Project Name: SUNPORT PARK

February 6, 2013

13DRB-70405 MAJOR – SITE DEVELOPMENT PLAN FOR BUILDING PERMIT

PETER BUTTERFIELD, ARCHITECT agent for LAXMI MANAGEMENT LLC requests the referenced/ above action for LOT 4-B, BLOCK 4-B, **SUNPORT PARK**, zoned I-P and located on the east side of TRANSPORT ST SE between SUNPORT BLVD SE and WOODWARD RD SE, containing approximately 1.9 acres. (M-15)

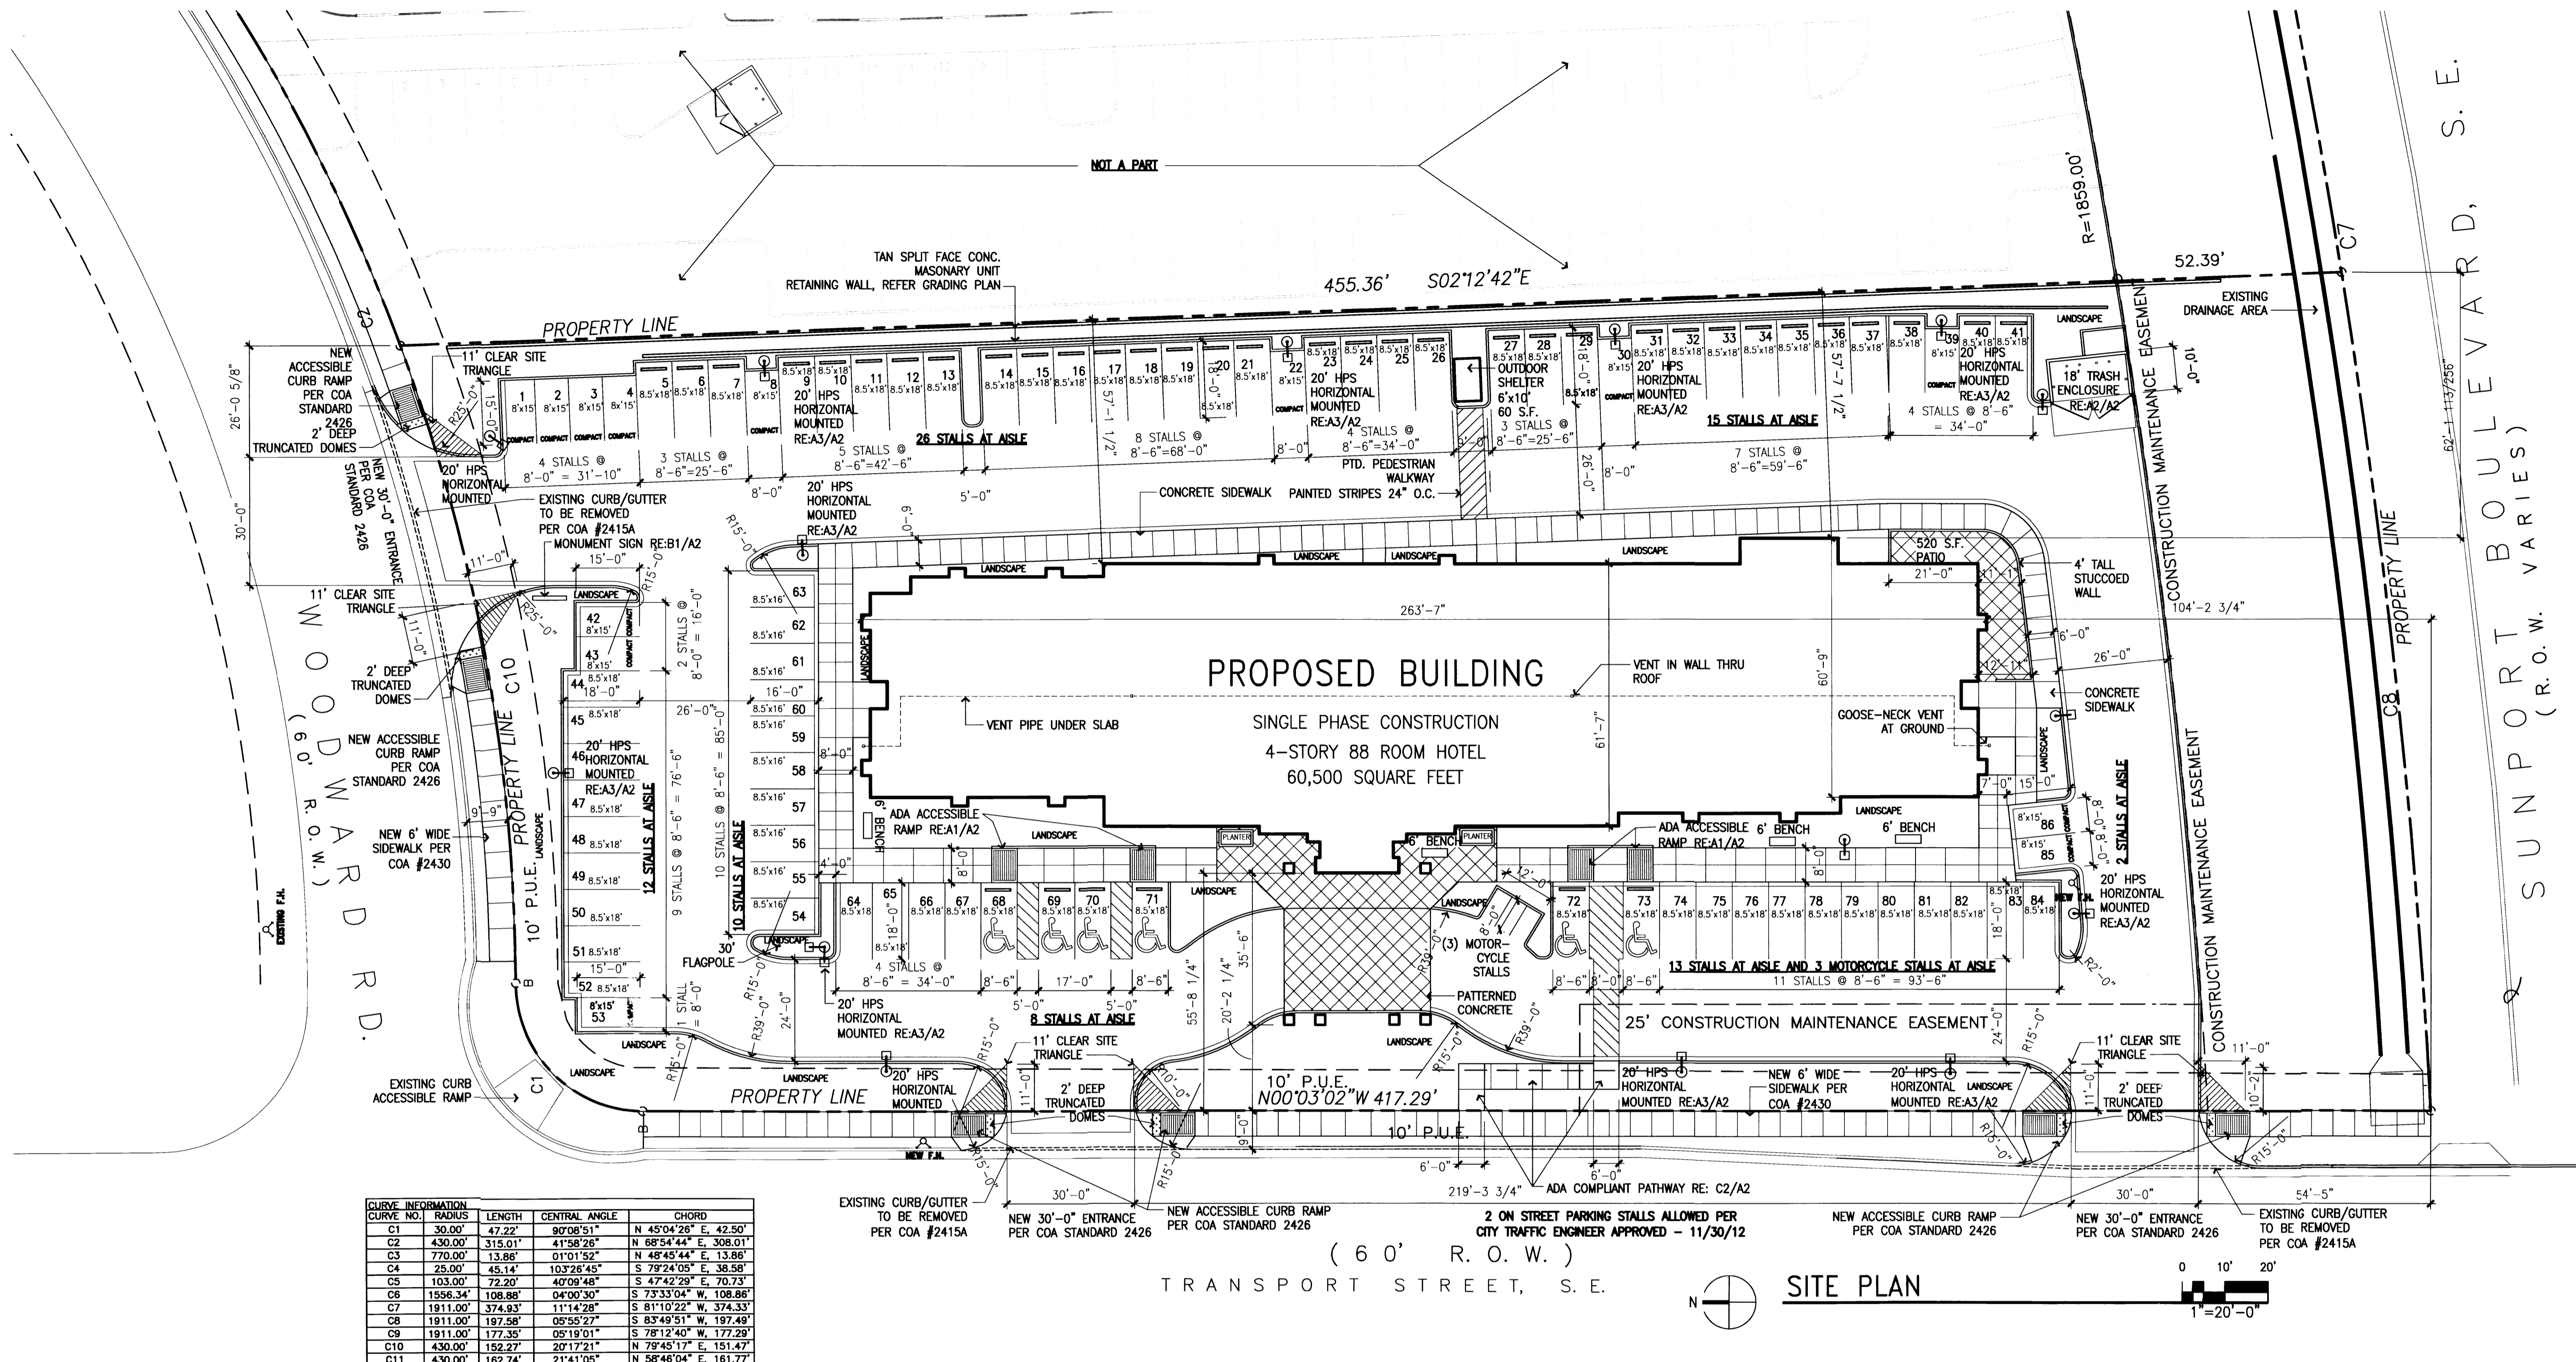
The Site Plan shows a large amount of construction (landscaping, paving, curbing, parking, etc.) within the existing construction maintenance easement. Prior to constructing anything within a construction maintenance easement, written permission from Street Maintenance (Contact: Phil Romo, 857-8021) must be obtained.

Provide recording information for all existing easements.

Clearly demonstrate the ADA pathway from the public sidewalk to the building. Show all ramps.

Provide details for all proposed ramps.

Ramps within City of Albuquerque right of way must have truncated domes.

All internal sidewalks must be a minimum of 6 feet in width.

Define the width and length of all parking stalls.

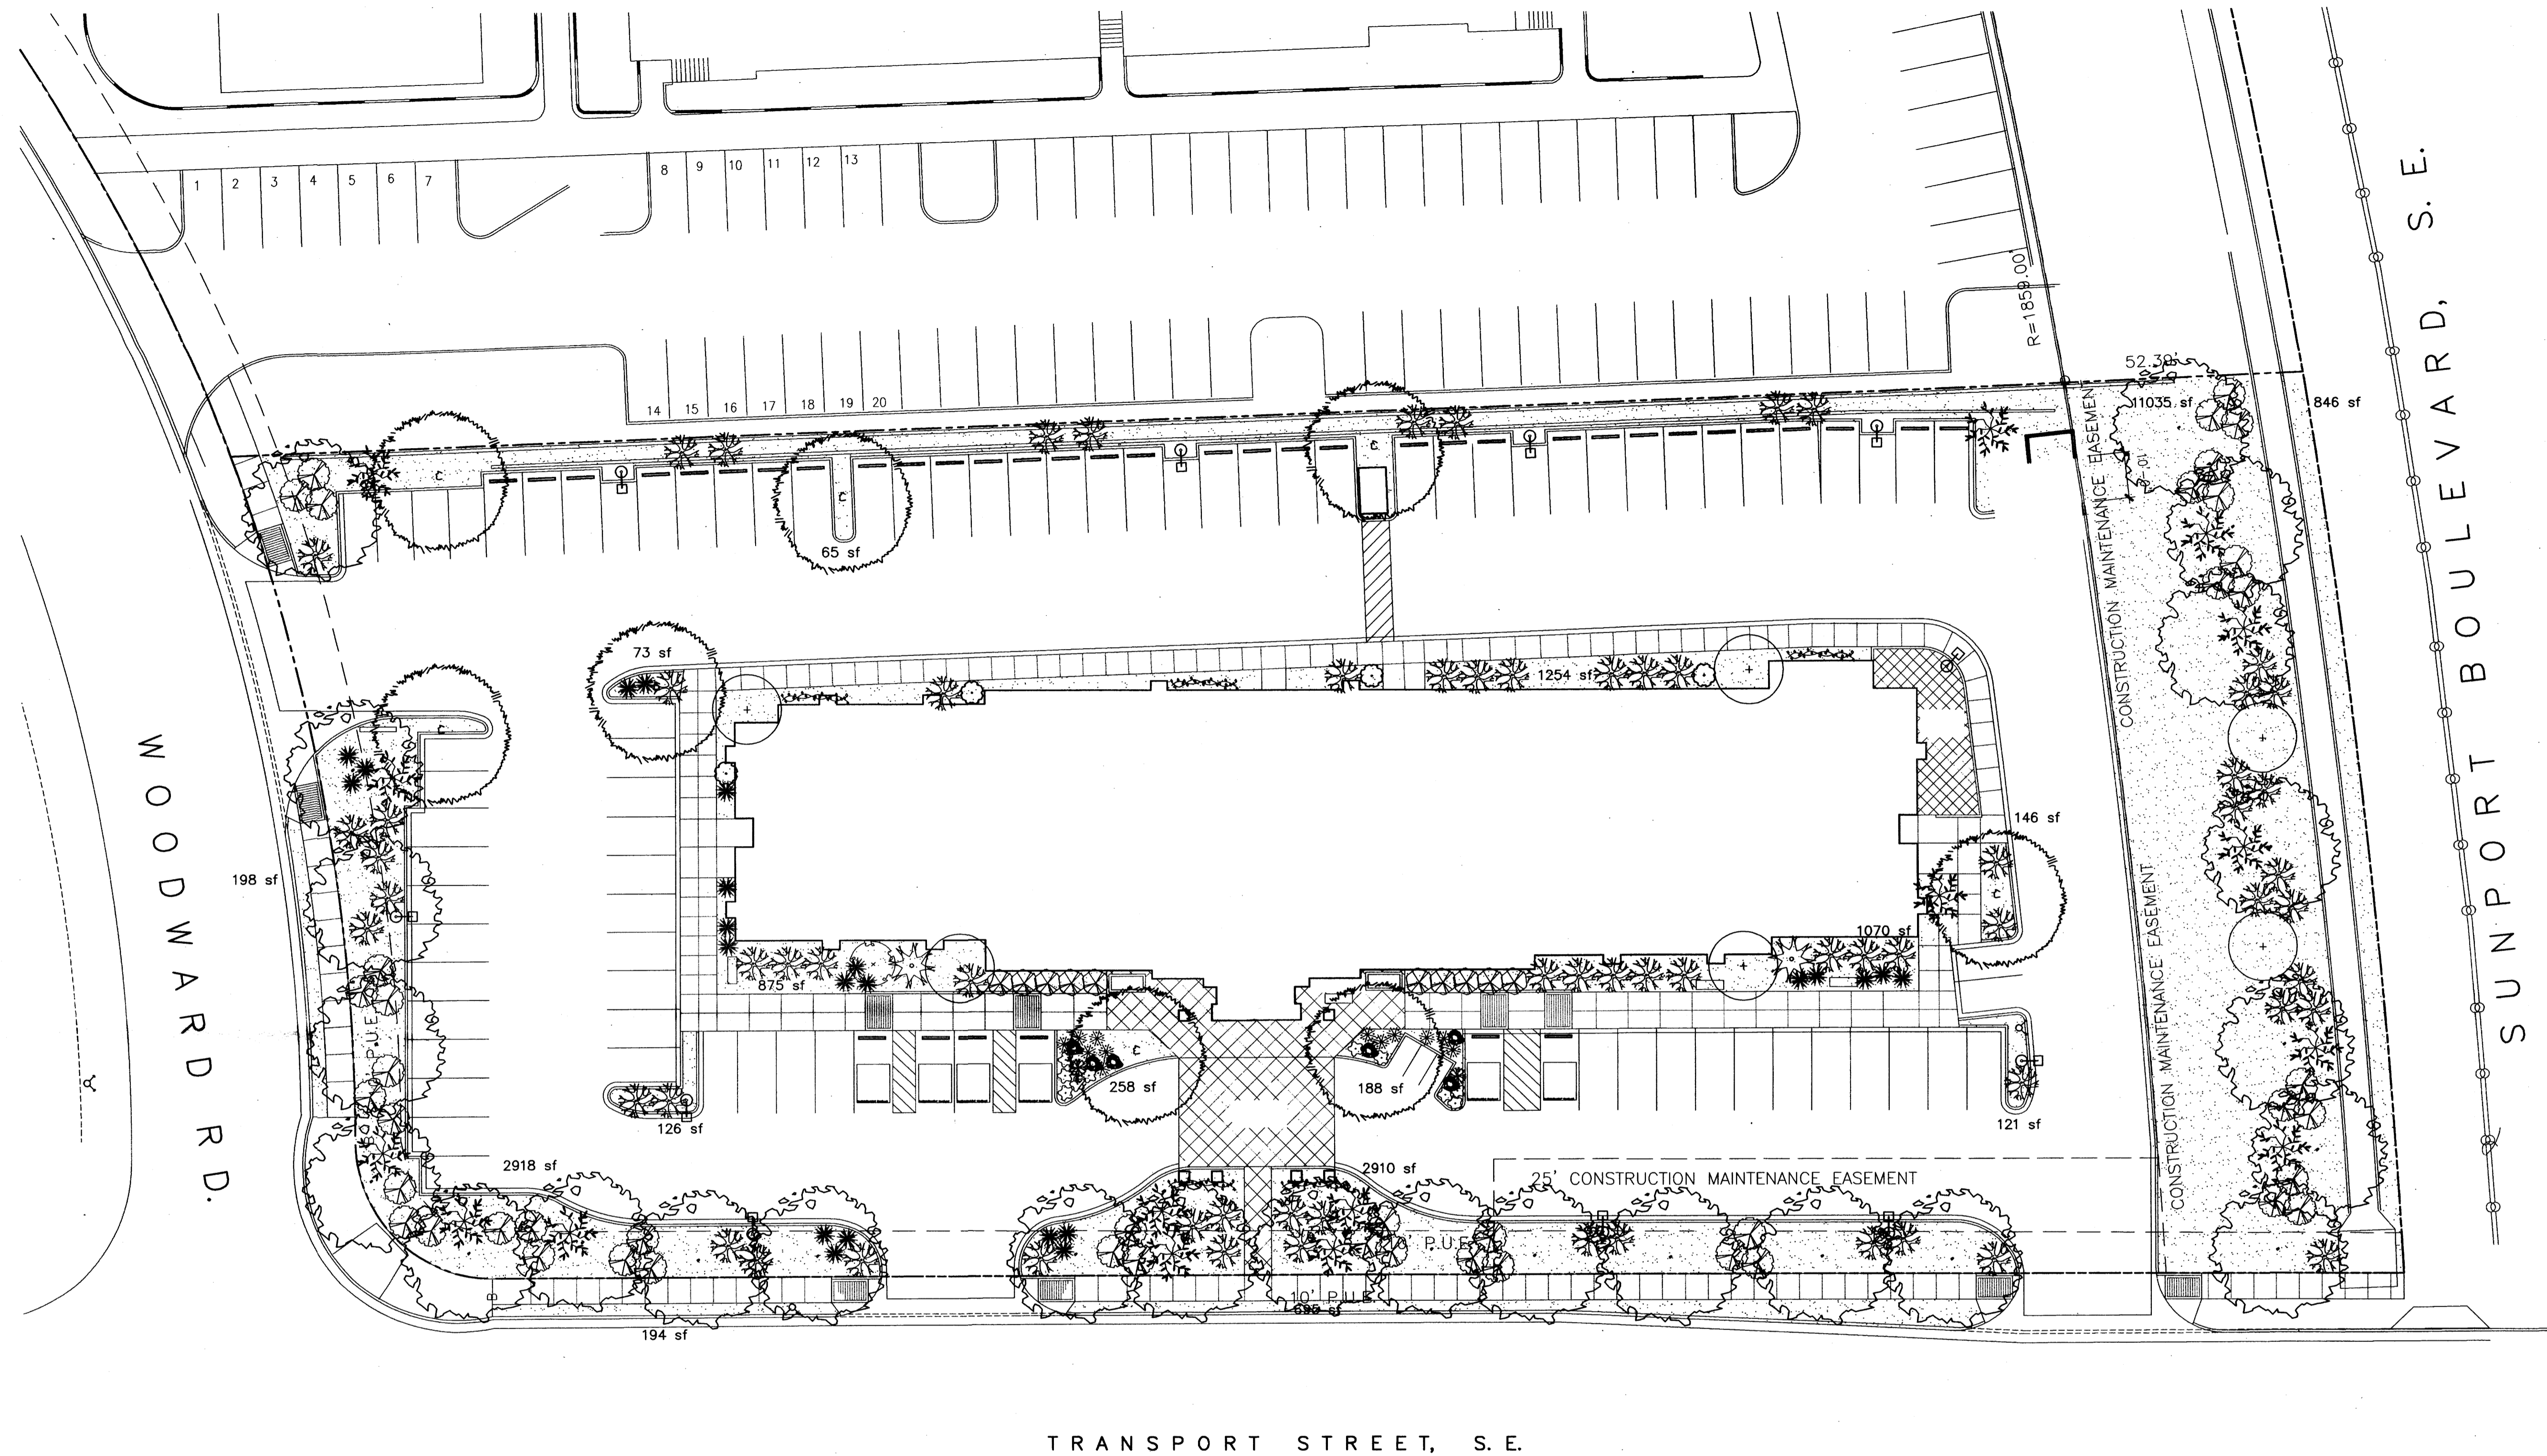
Demonstrate that the signs and landscaping do not interfere with the sight distance of the entrances. Please add the following note to the Landscaping Plan: "Landscaping and signing will not interfere with clear sight requirements. Therefore, signs, walls, trees, and shrubbery between 3 and 8 feet tall (as measured from the gutter pan) will not be acceptable in this area."
